# **A46 Newark Bypass**

**Scheme Number: TR010065**

## **Statement of Common Ground with Newark and Sherwood District Council 'NSDC'**

**Statement of Common Ground with  
Newark And Sherwood District Council**

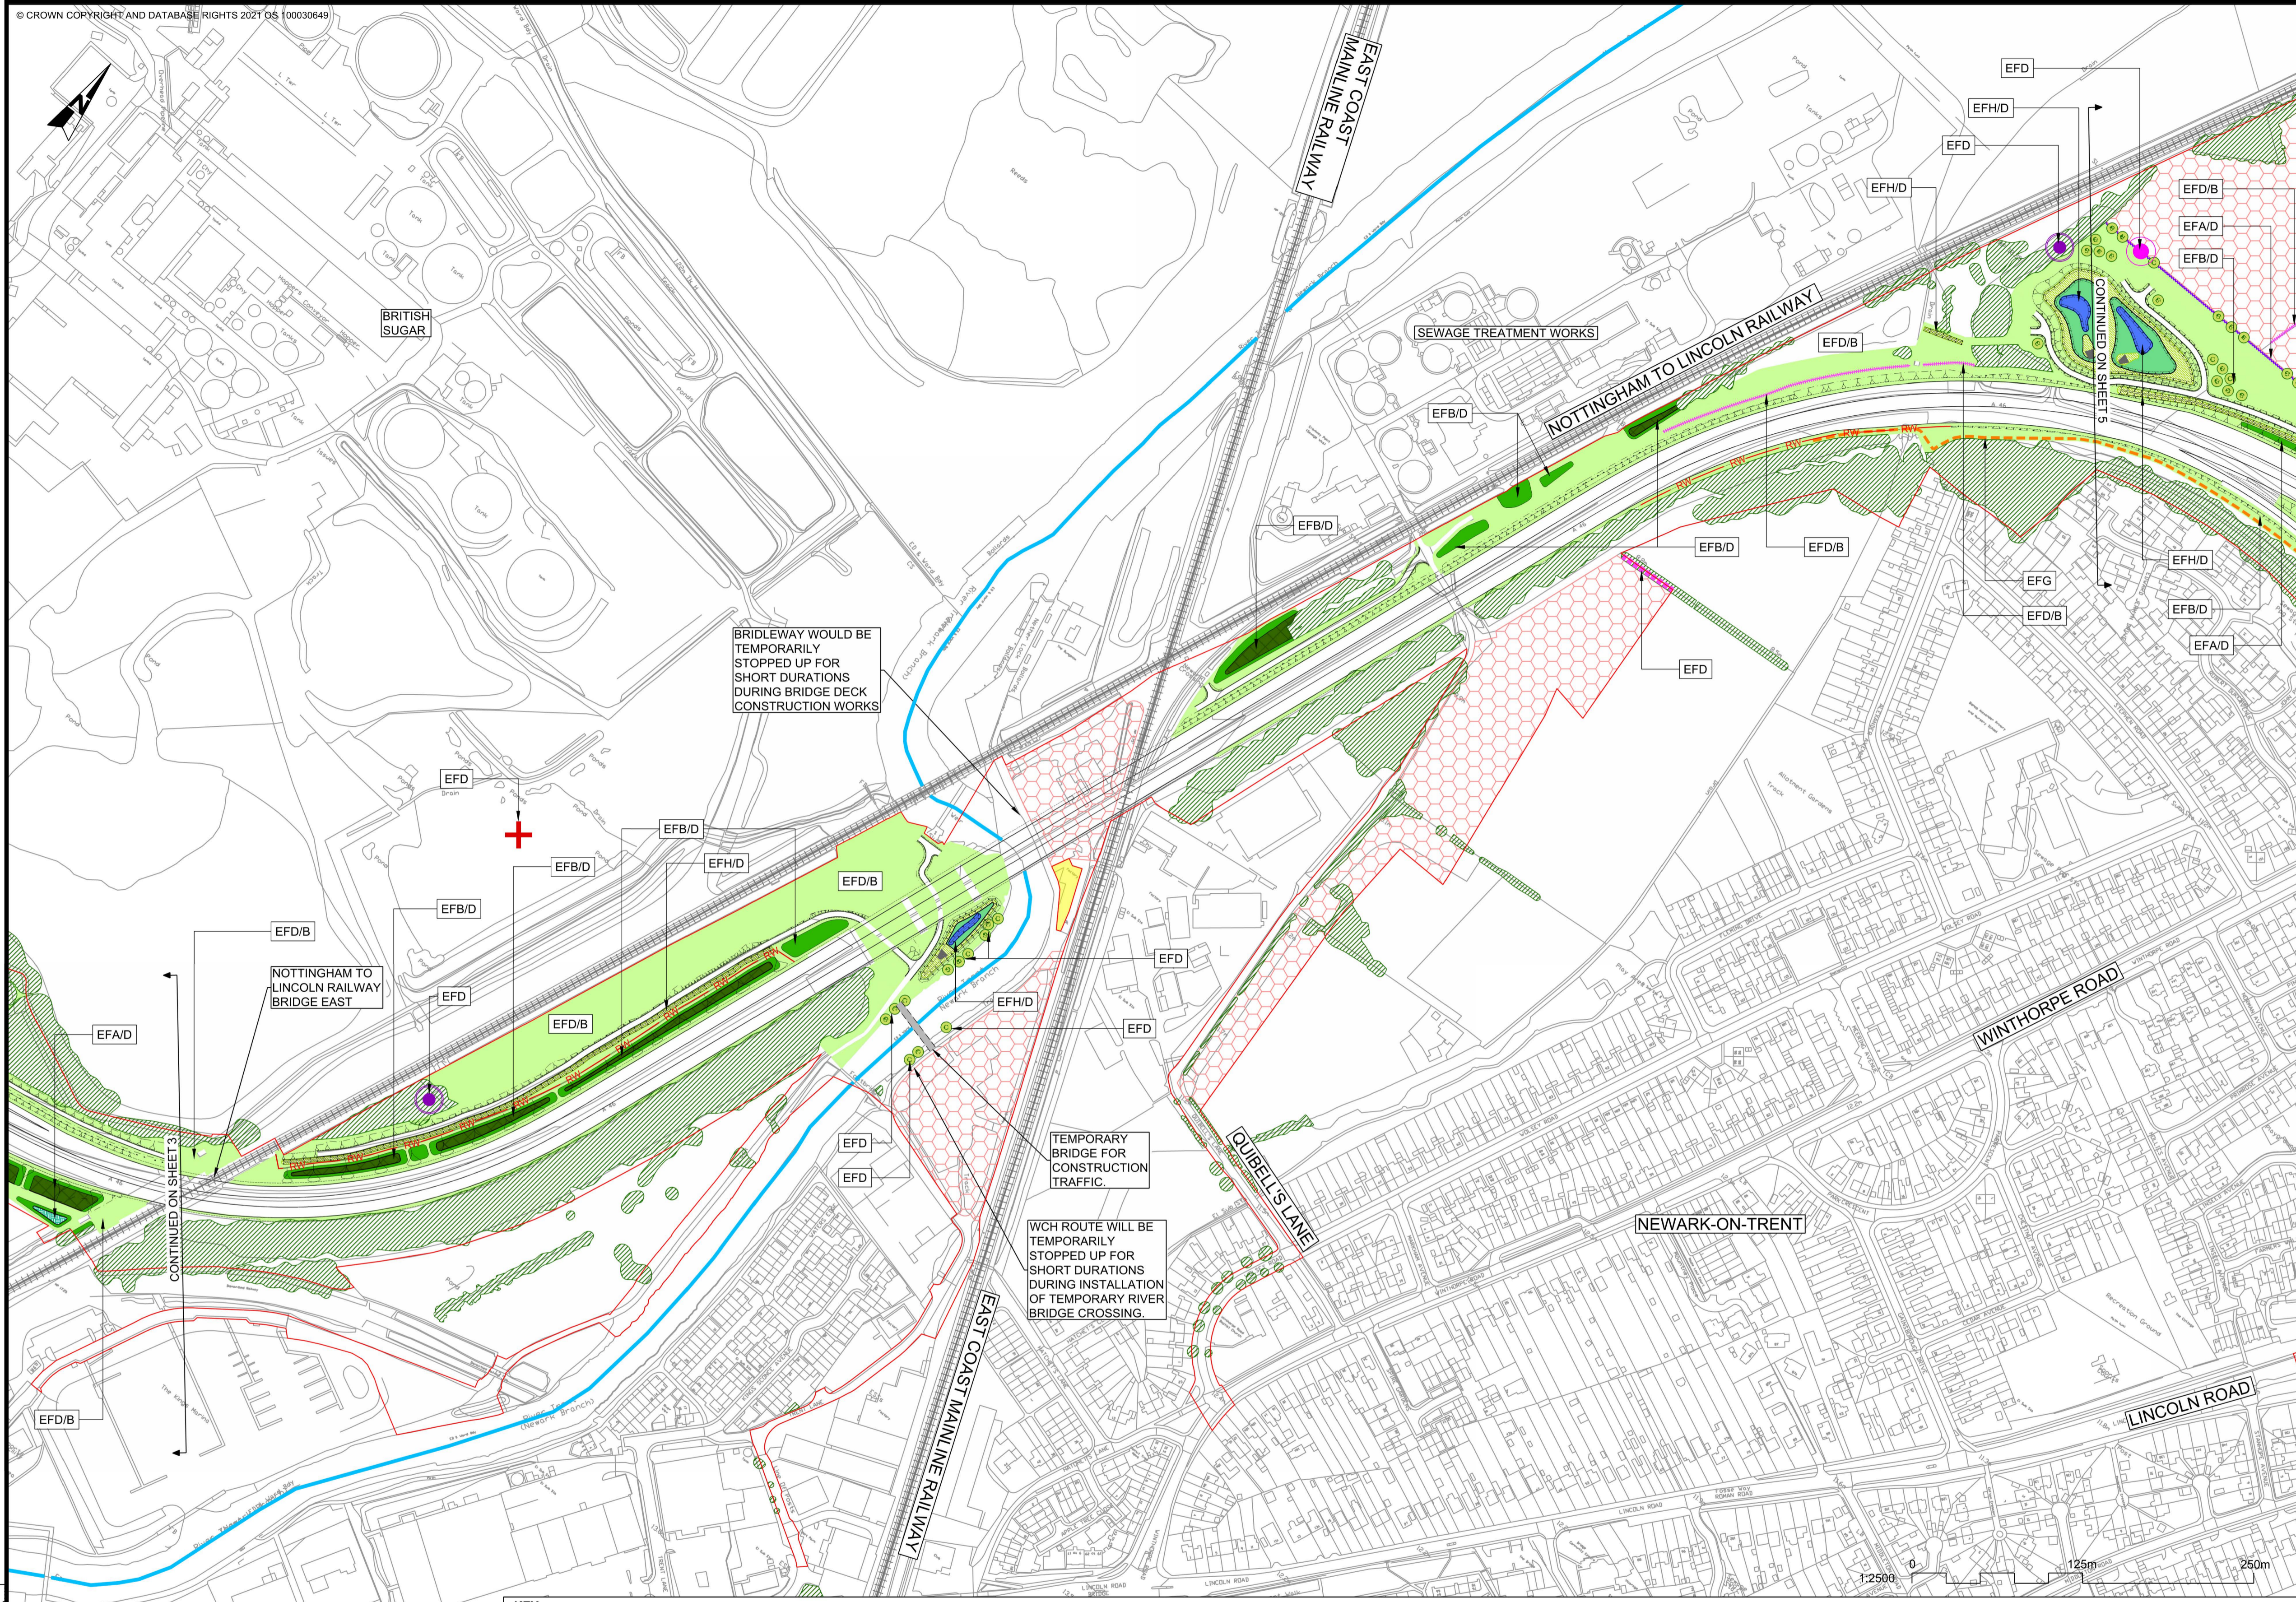
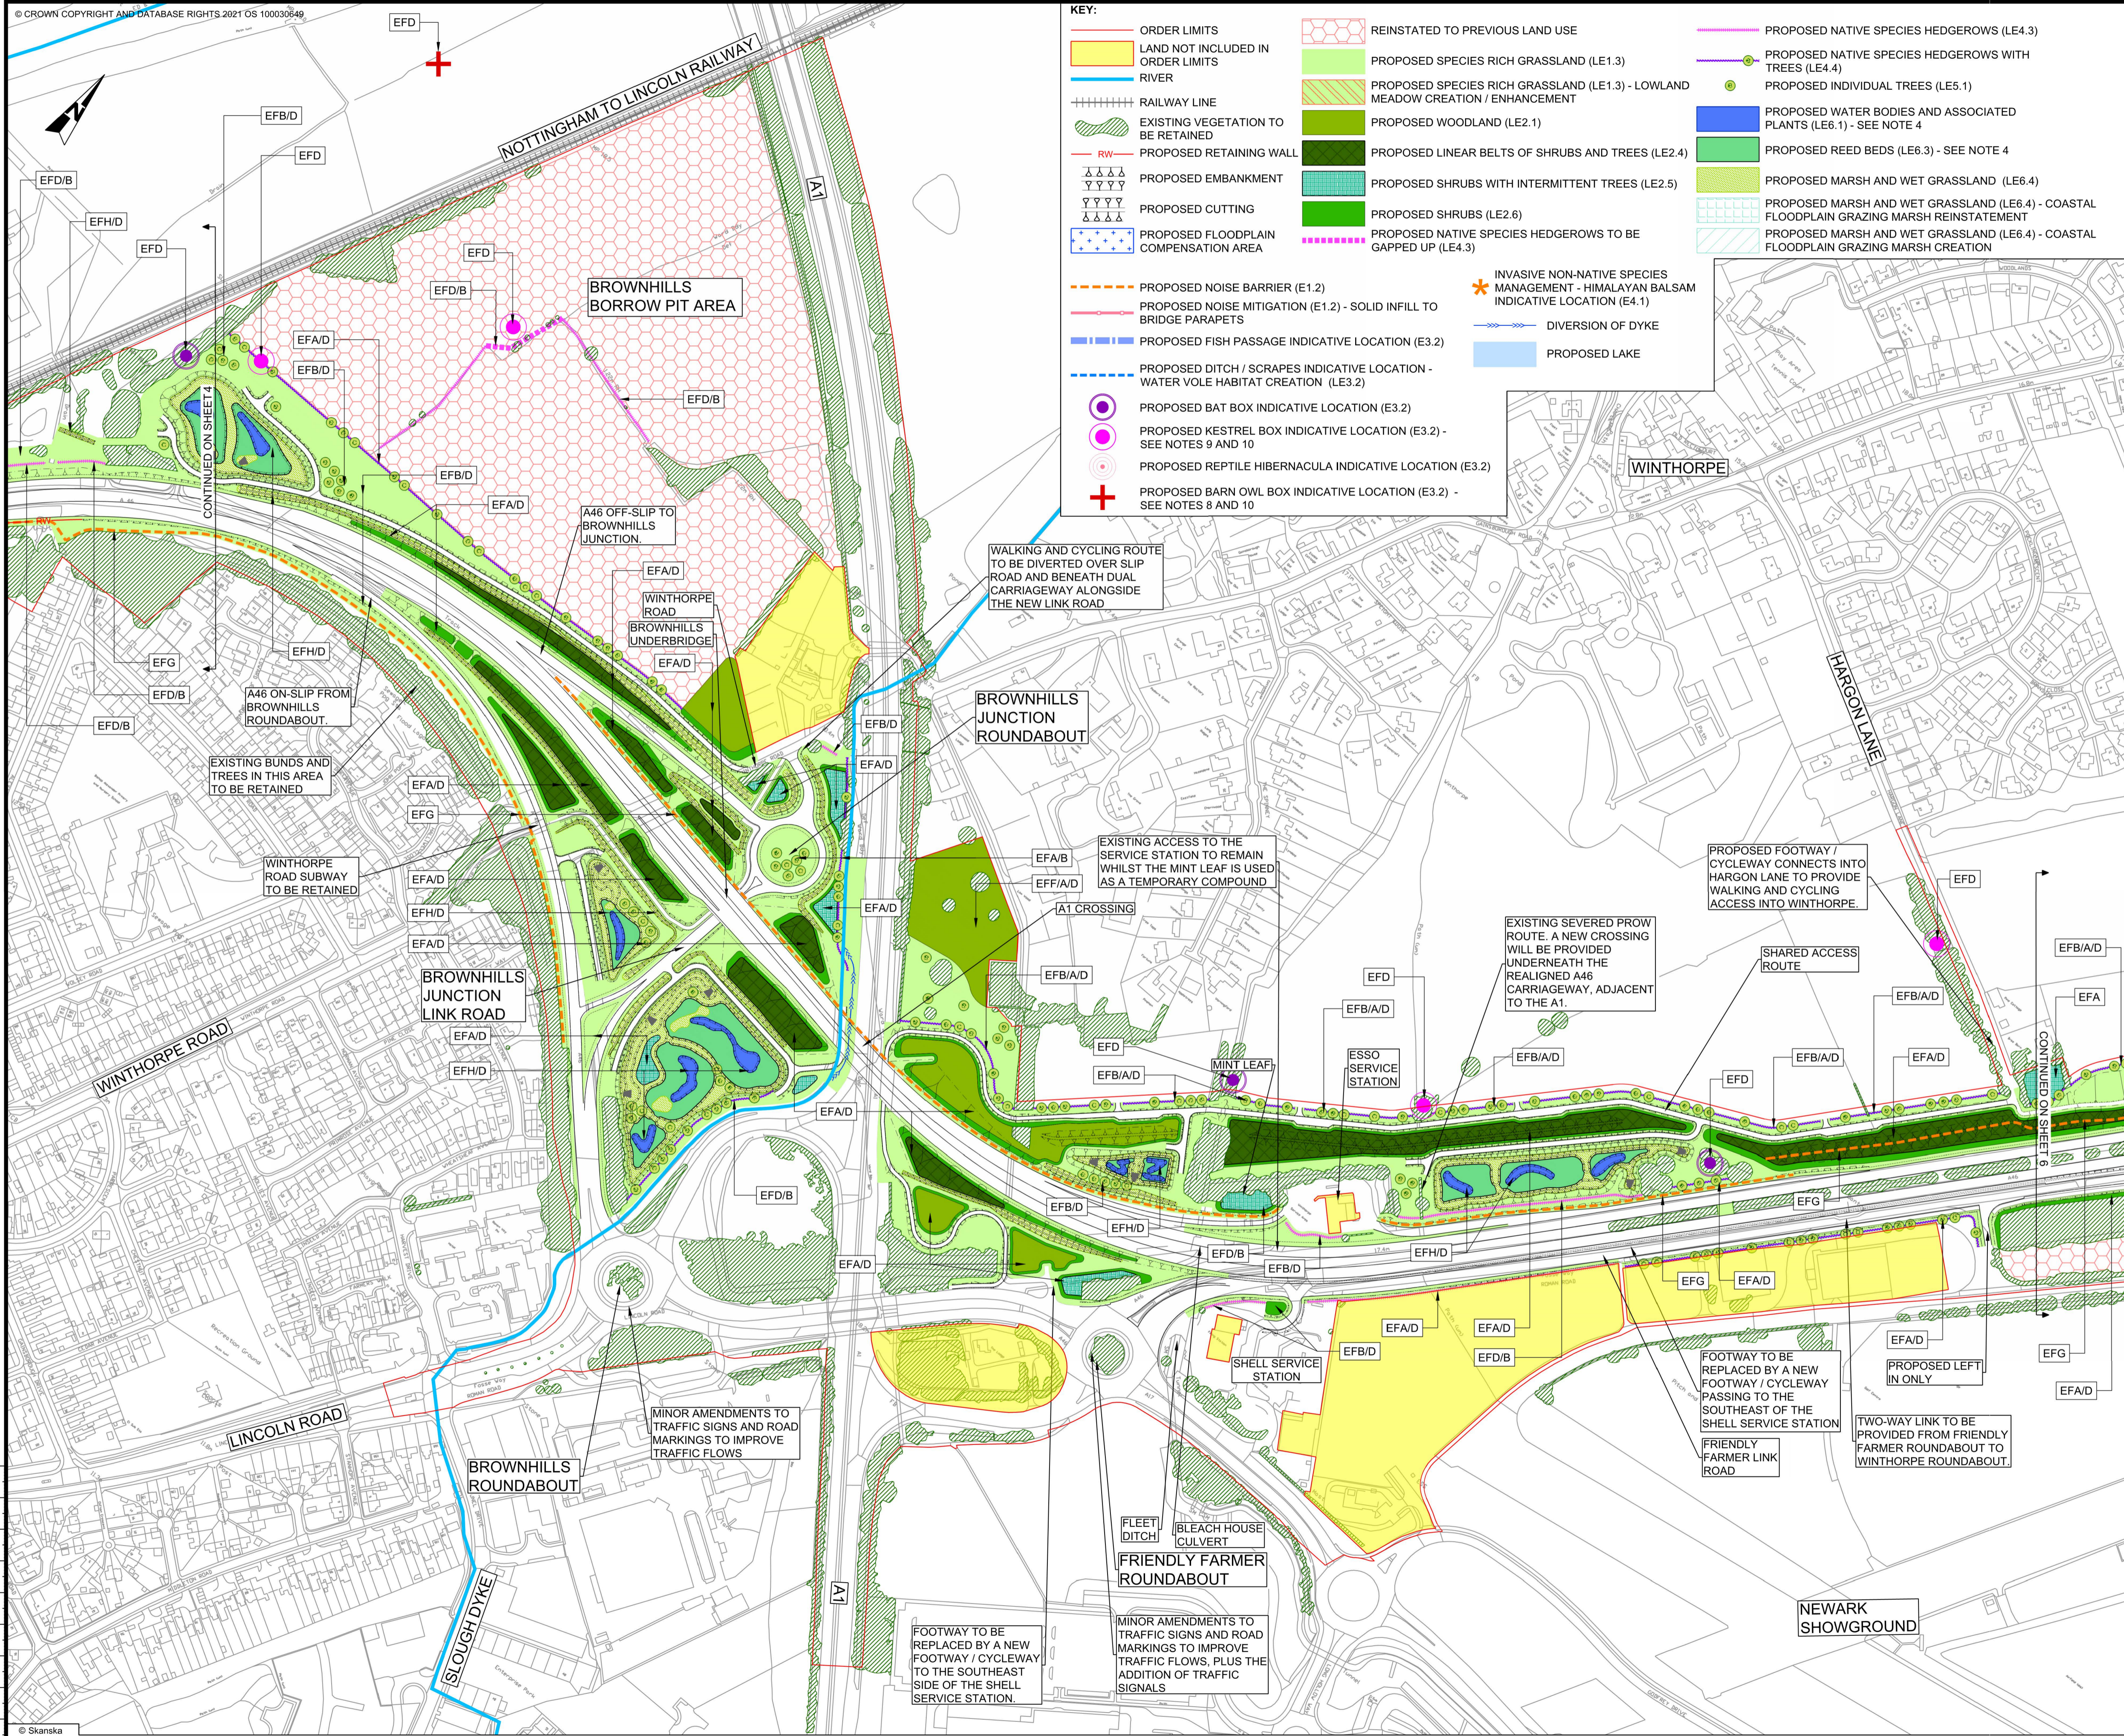
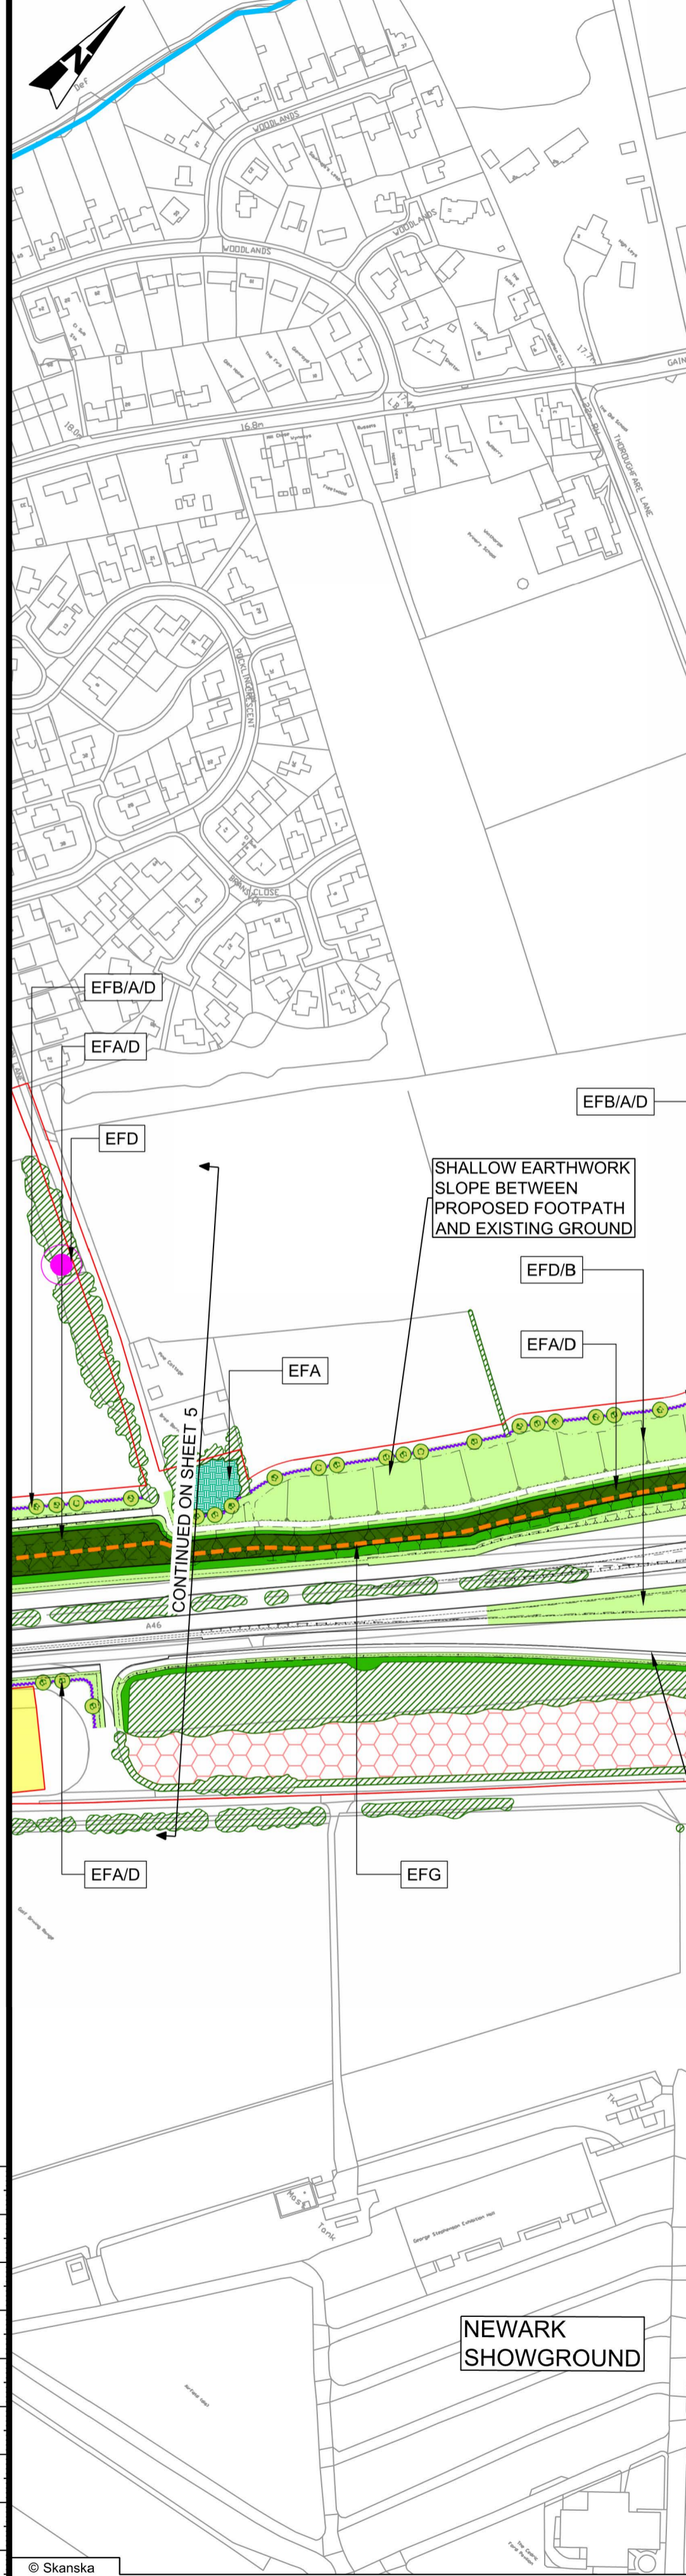
Issue No.	Issue	Document Reference	Newark and Sherwood District Council's Position	The Applicants Position	Status	Date status confirmed
12.	Design (including justification for any flexibility being sought)	Chapter 2 The Scheme of the Environmental Statement [APP-046] 6.2 Environmental Statement - Figure 2.3 Environmental Masterplan [AS-026]	<b>Cattle Market flyover</b> On the fly-through video the structure of the elevated over-pass at the Cattle Market junction appears as a stark and imposing concrete structure. This may be in part due to the animation which depicts it as being very bright in colour and therefore standing out vividly. The Council would want to understand proposals to ensure the visible impact of the final structure is minimised and/or mitigated as far as practicable.	Consideration has been given to the aesthetic finish of the structure during the design development to help to reduce the visual prominence of the structure and to reflect finishes on existing structures such as that of Smeaton's Arches just to the north of the new junction. Further details of these can be found within Chapter 2 The Scheme of the Environmental Statement [APP-046] and 6.2 Environmental Statement - Figure 2.3 Environmental Masterplan [AS-026]. Planting of trees and shrubs has also been considered and incorporated wherever feasible to help break up the visual mass of the structure, with planting softening the built form and aiding screening over time, particularly from properties such as those in Sandhills Park affording near distance views. The assessment of landscape and visual effects and associated design and mitigation measures are described in 6.2 Environmental Statement - Figure 2.3 Environmental Masterplan [AS-026] and presented in 6.2 Environmental Statement - Figure 2.3 Environmental Masterplan [APP-026]. Part of the Detailed Design process will be to define the finish of the retaining walls forming the Cattle Market Flyover. This will be a masonry type façade and not a bare concrete finish.	Under Discussion	16/10/2024
